Date: 21-May-2024
Our Ref: 2023/90772

**Discharge of conditions 3 (CEMP), 7 (waste collection), 14 (soft landscaping), 17 (boundary treatments) and 25 (tree/shrub planting) of previous permission 2020/90725 for erection of 68 dwellings with associated access, parking and open space (revised plans)
Land at, Penistone Road, Fenay Bridge, Huddersfield, HD8 0AW
Application Number: 2023/90772**

Drawing No. 22/491/EST/EXT/001 | Revision: A

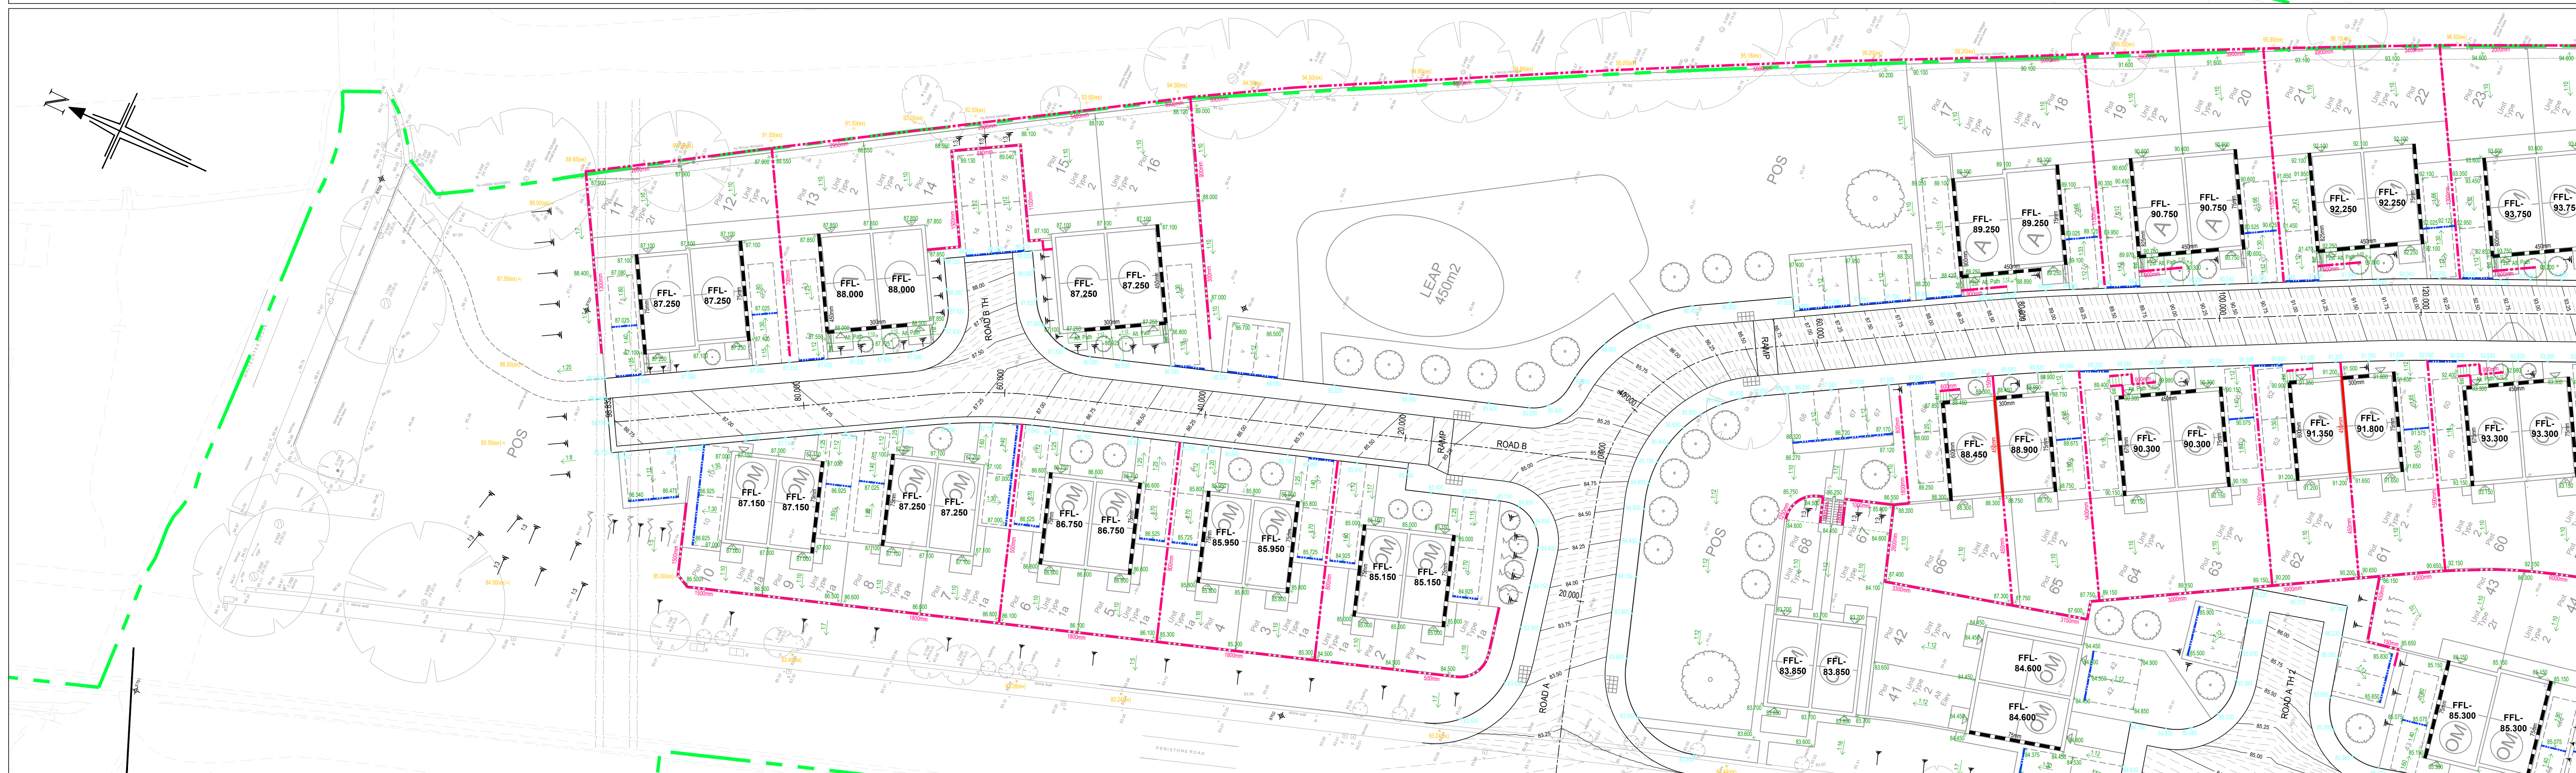
The plans do not show typical elevational appearances for one of the three types of traditional boundary treatment. Furthermore, the fourth boundary treatment is retaining walls, which have a dedicated plan. Within this plan several different types of retaining wall are proposed across the site, but again no typical elevations are provided (only written descriptions are provided). The submitted details are insufficient to assess the visual and residential impacts of the walling.

Additionally, the proposal includes extensive excavations near to a veteran oak. There are concerns over potential impacts upon the tree's health. No evidence has been submitted, such as an Arboricultural Impact Assessment, to demonstrate these works can be implemented without undue harm to the tree.

Finally, no details have been provided pursuant to requirement 17(a), preventing this being assessed and failing to comply with the condition. Condition 17(a) requires that the following be provided:

(a) An evaluation of the structural integrity of existing walls around the site boundary and any proposals for their re-construction/replacement

In light of the above, insufficient details have been provided to undertake a full assessment and concerns are held over the details submitted. For the avoidance of doubt condition 17 is not hereby discharged.

Drawing Title	
Construction Management Plan	
Site	
Penistone Road, Fenay Bridge	
Scale @ A1	Date
1:500	06.03.23
Drawn	Checked
BH	.
Drawing No.	Rev.
FB-006	B

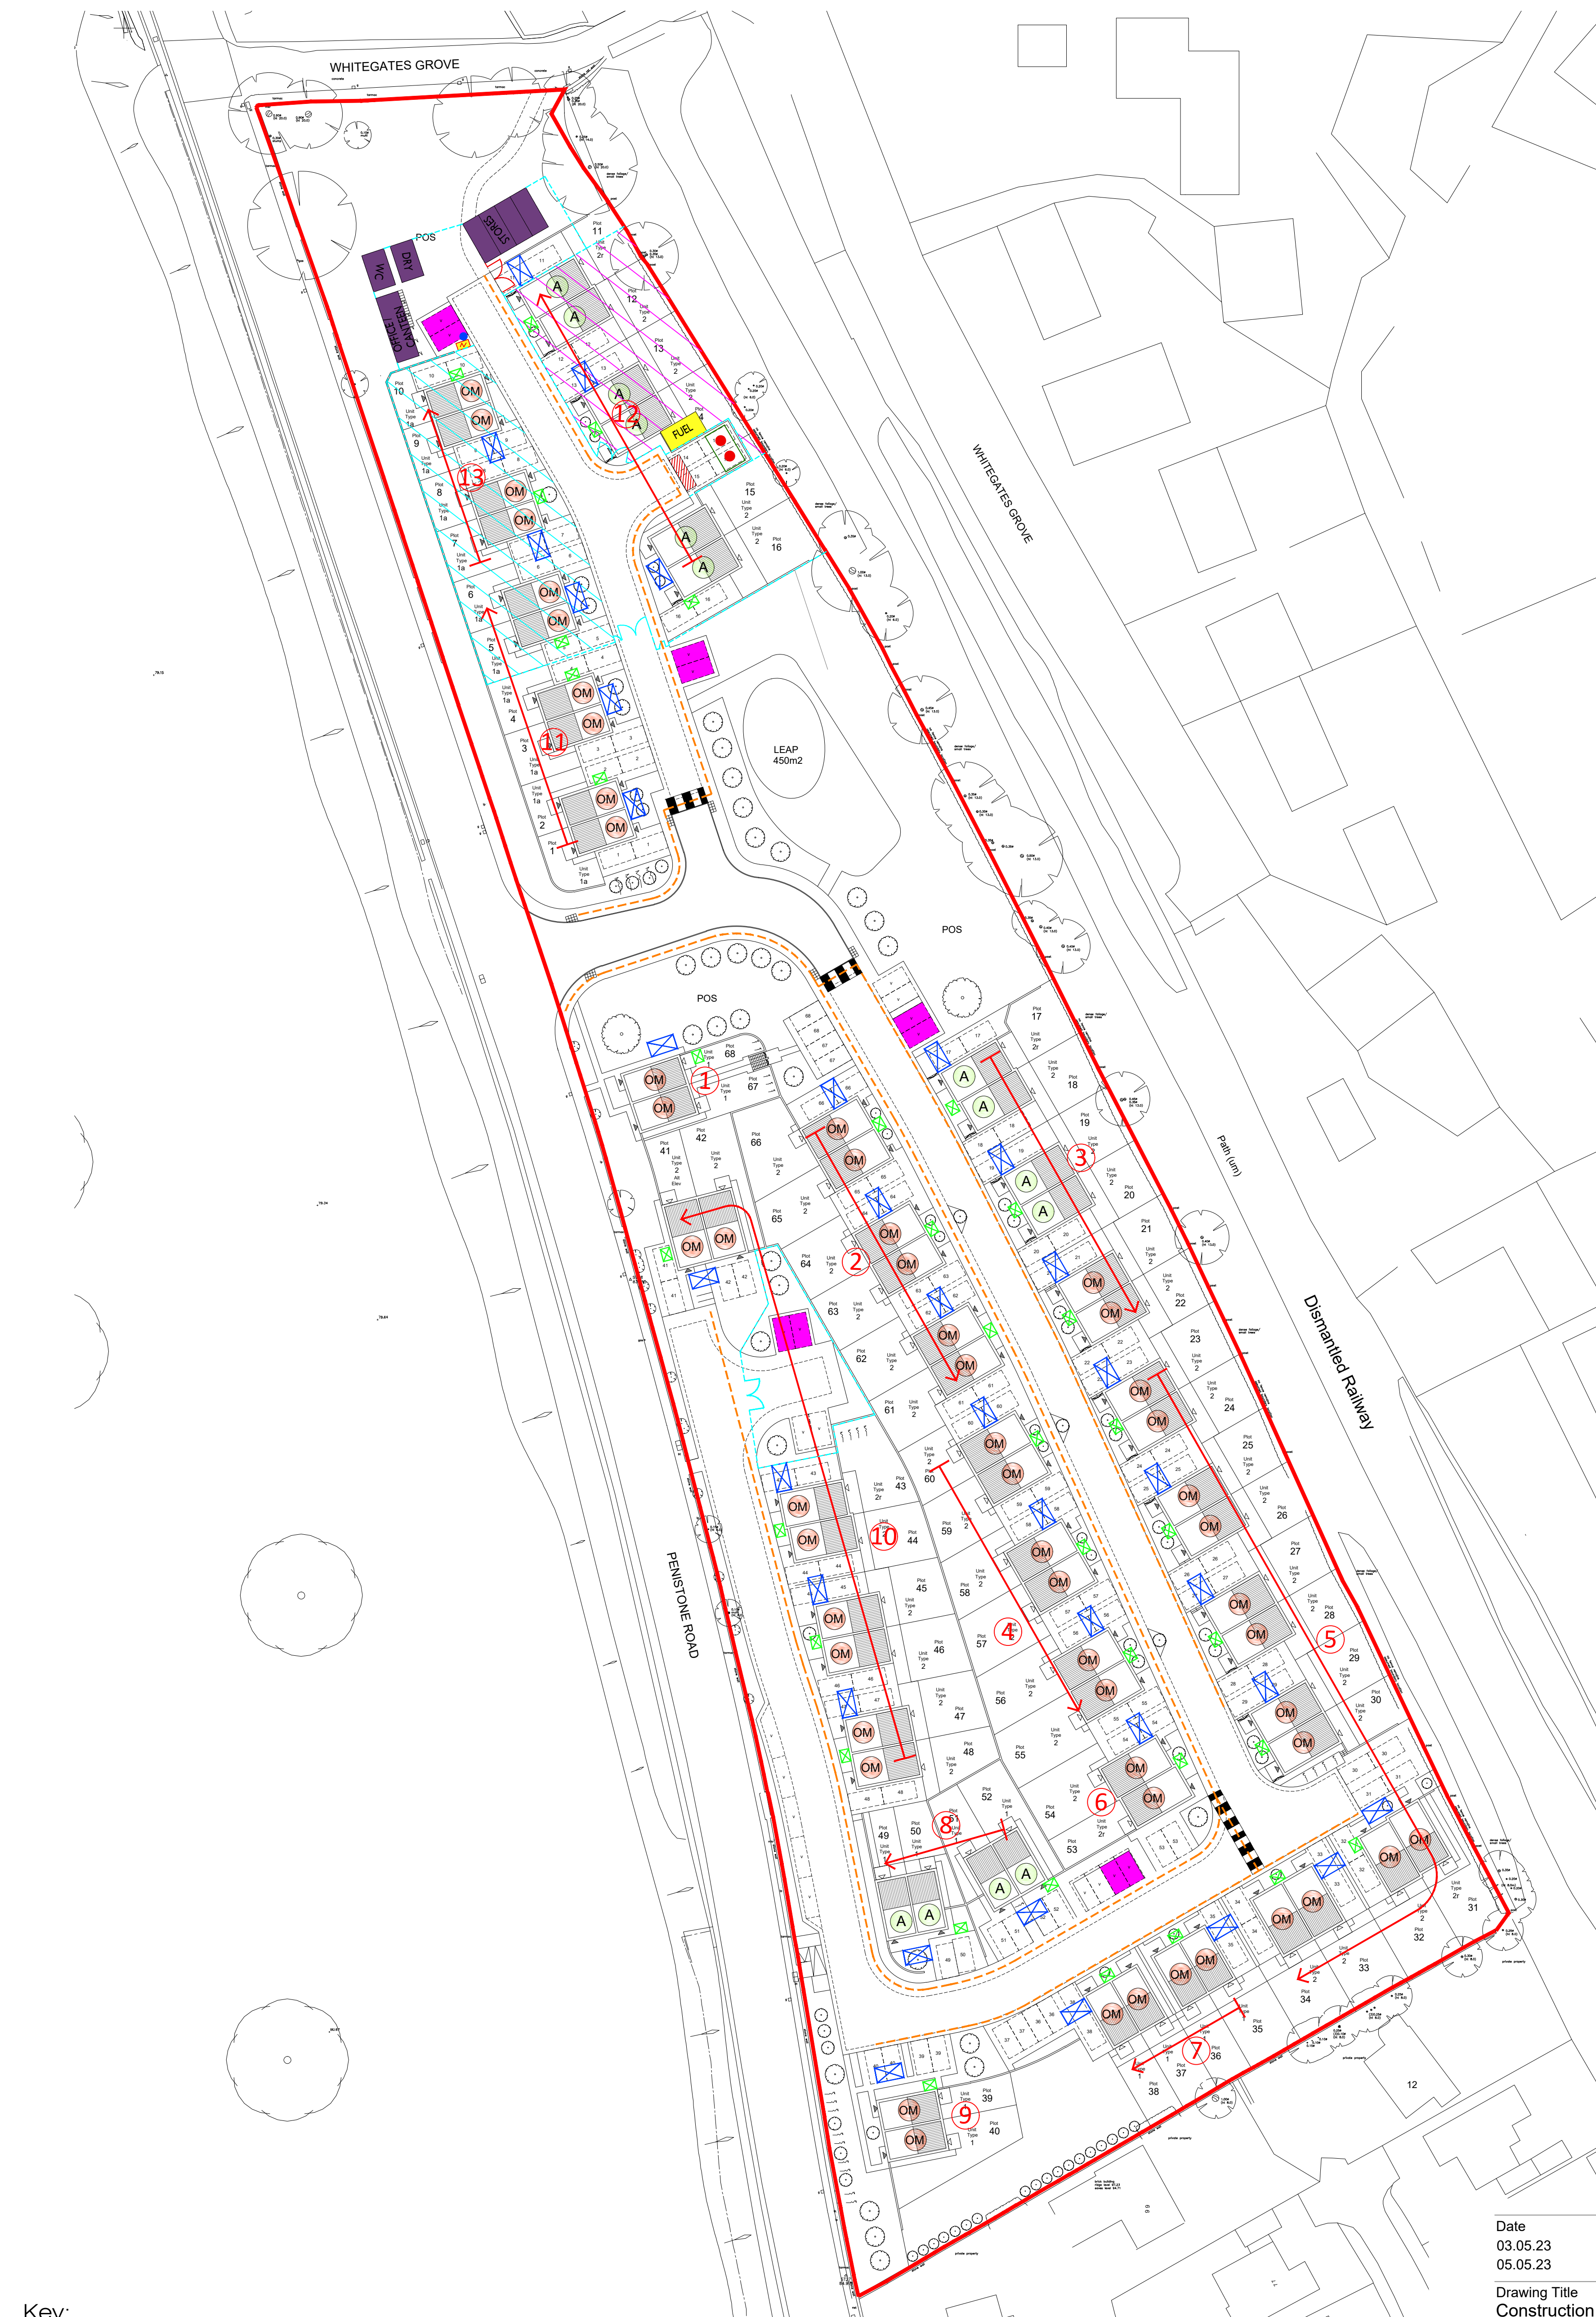
I can confirm that the submitted details are acceptable for the initial requirement of condition 7. However, be aware that condition 7 has the following ongoing requirement which must be adhered to, to ensure continued compliance with the condition:

Notwithstanding the above, K.C. Waste Strategy advise that continued discussions should be undertaken including a site meeting as works commence. This is in the interest of working collaboratively with the council's refuse collection service as the development progresses. To discuss this further please email waste.planning@kirklees.gov.uk.
